Re: Baze-Inoguchi Residence  
Building Permit #2006-188

The following is in response to the Intake Comments CST dated July 21, 2020 for your review.

Re: Baze-Inoguchi

I have reviewed the building department intake comments and made the following revisions in response to these comments.

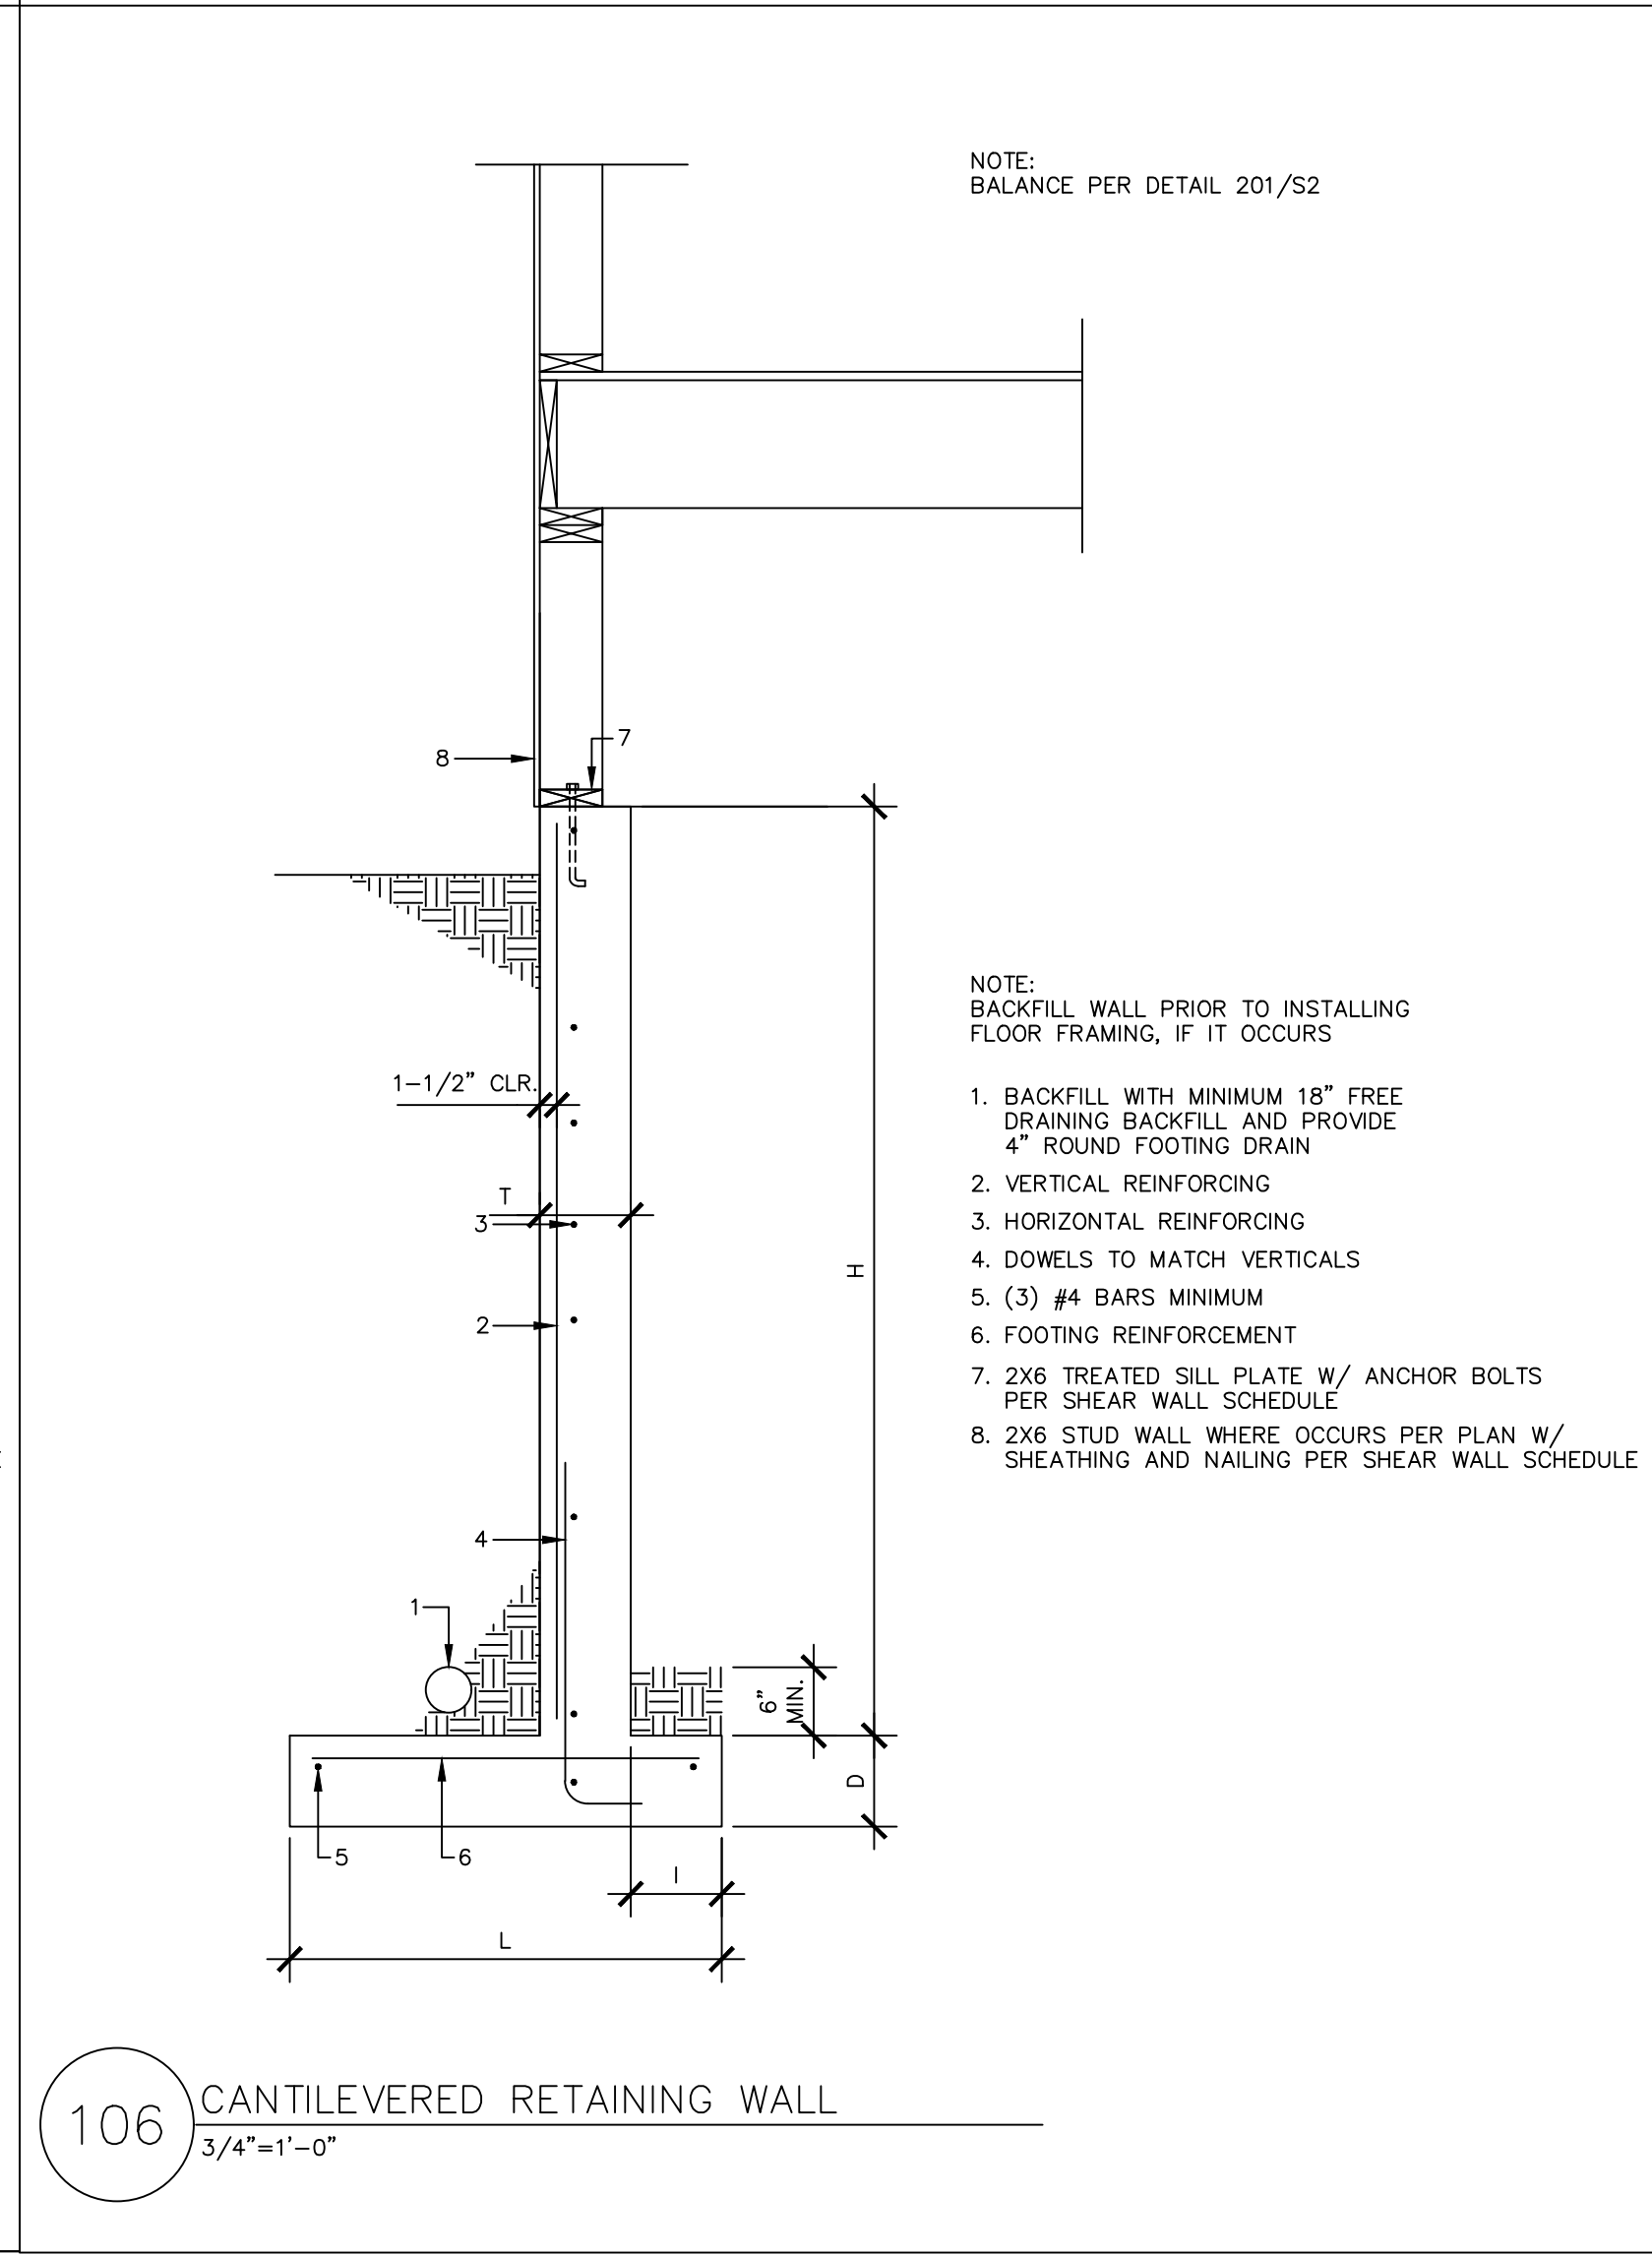
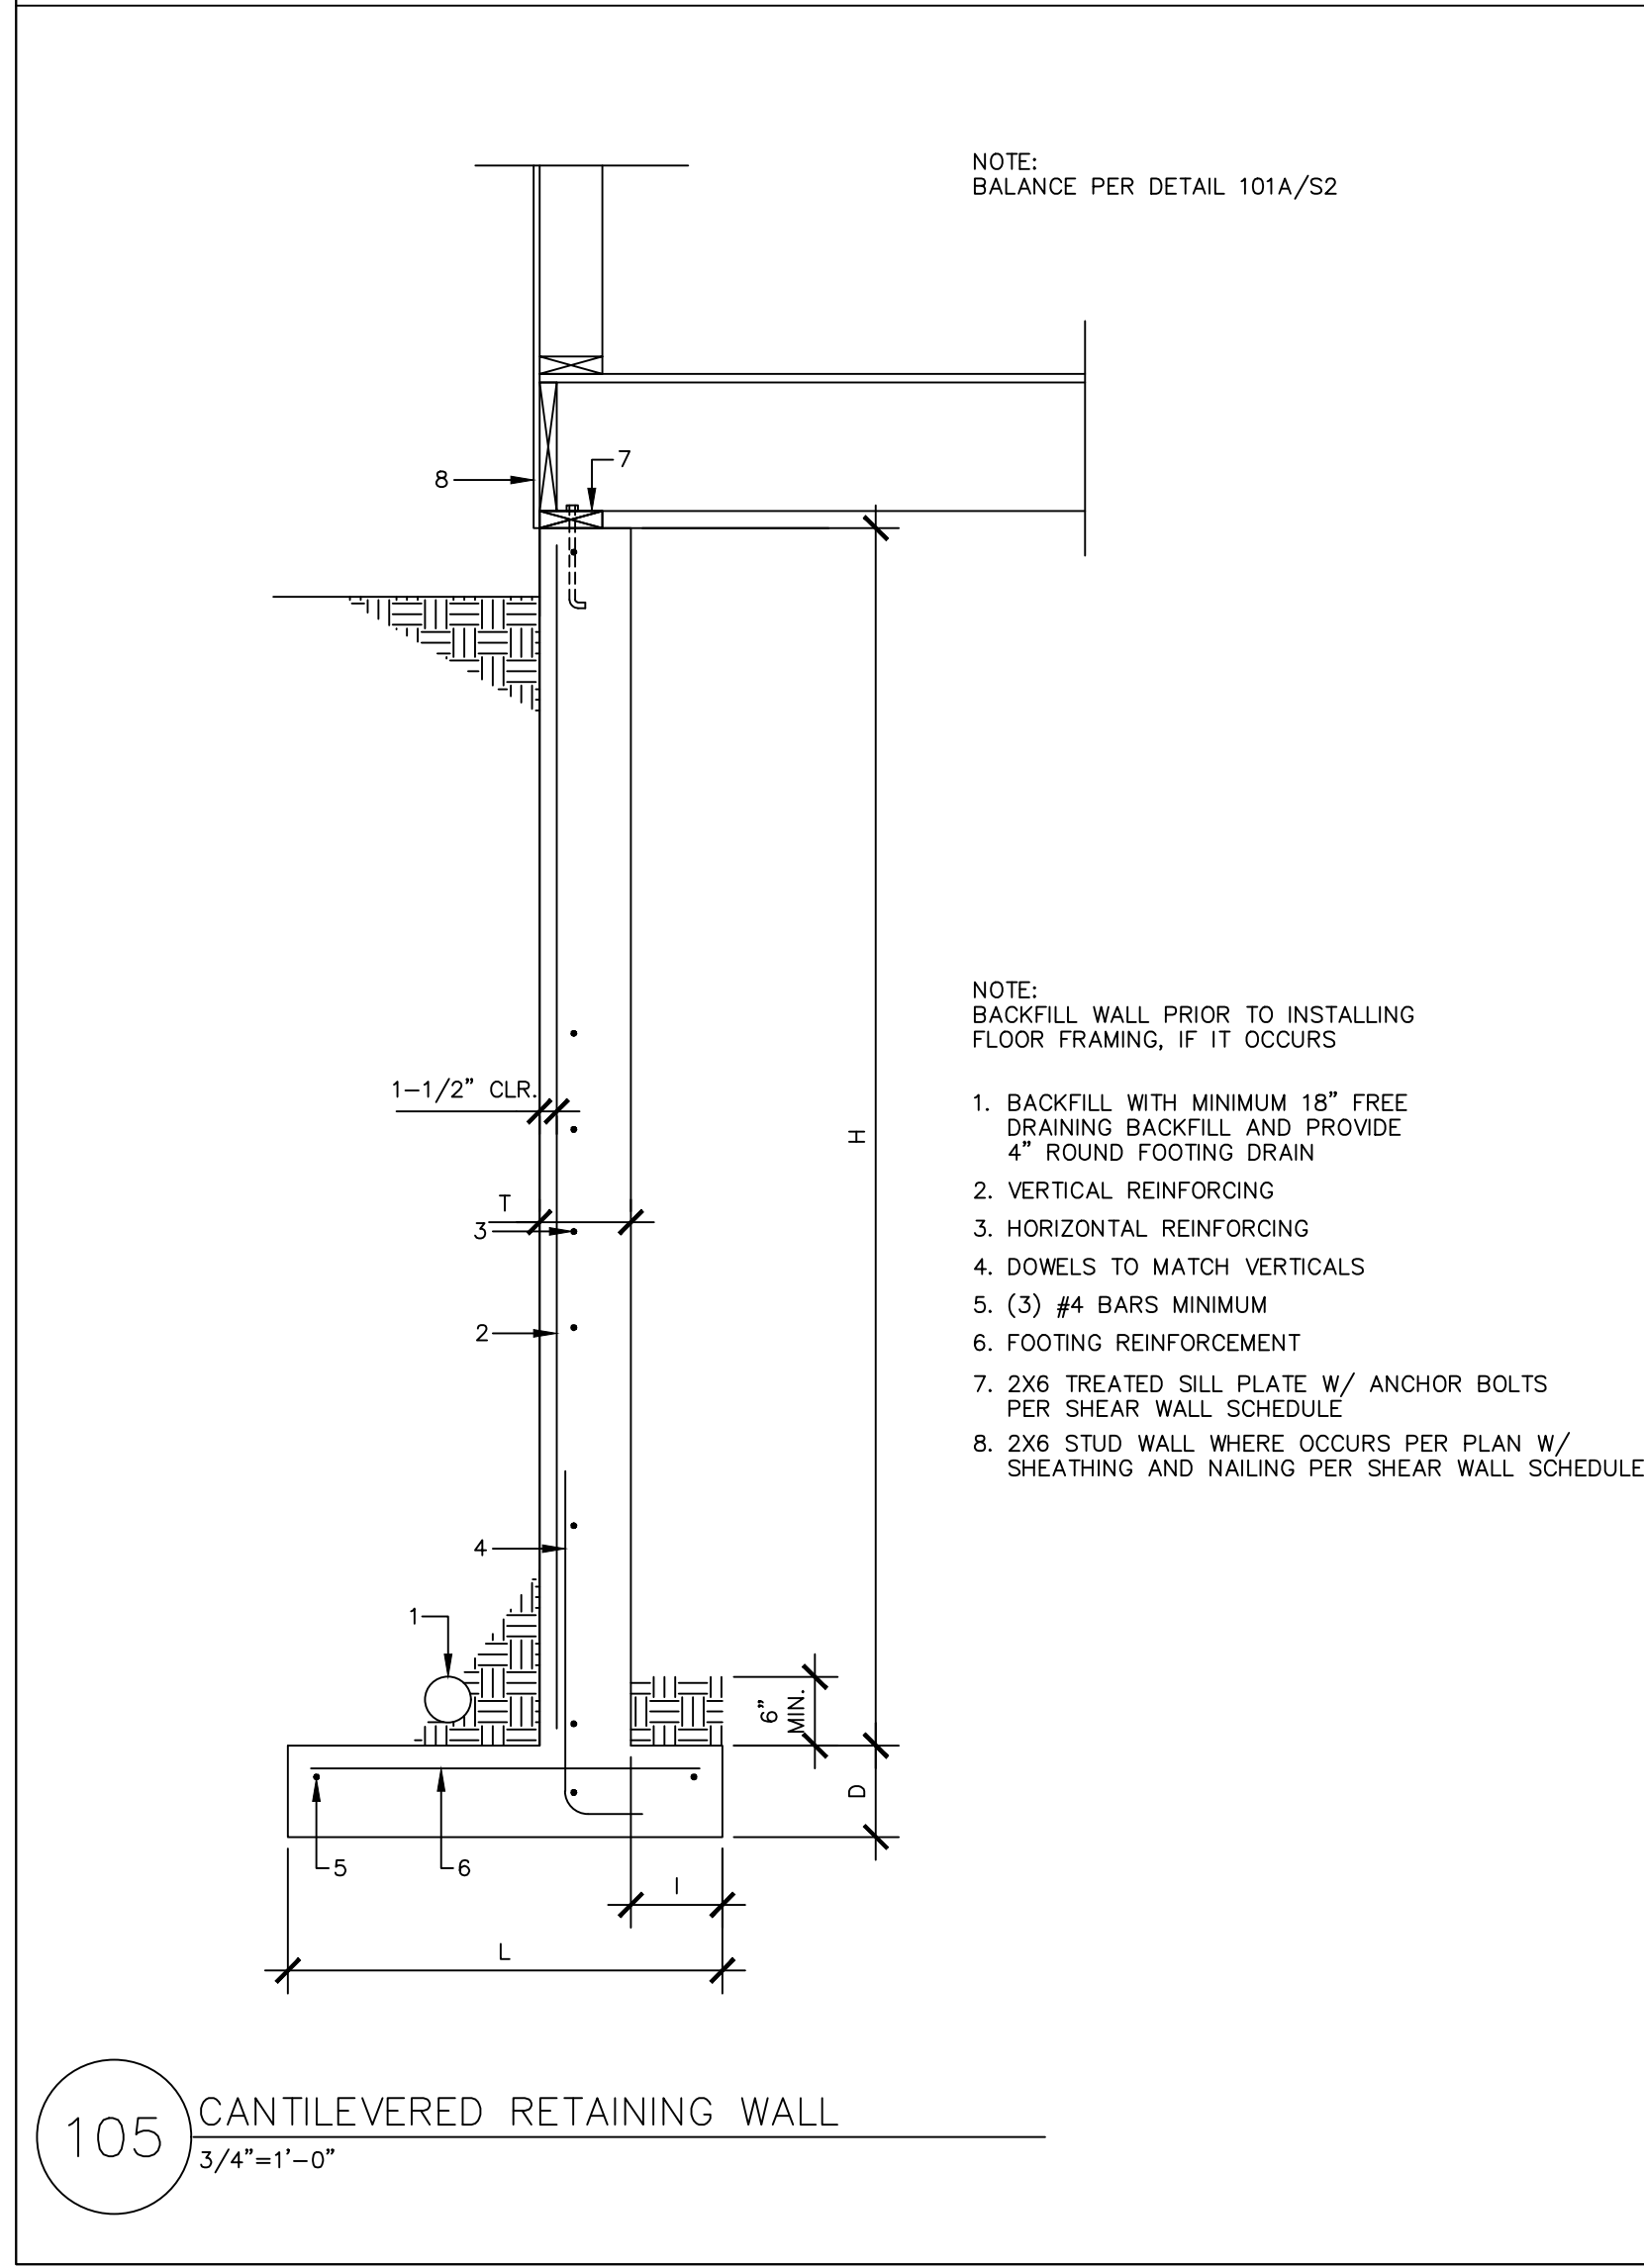
1. The lateral analysis has been revised using  $K_{zt} = 1.9$ . The revised calculations and the sheet S1 with the revised shear wall plans are attached.
2. The retaining wall calculations and a updated sheet S3 are attached.
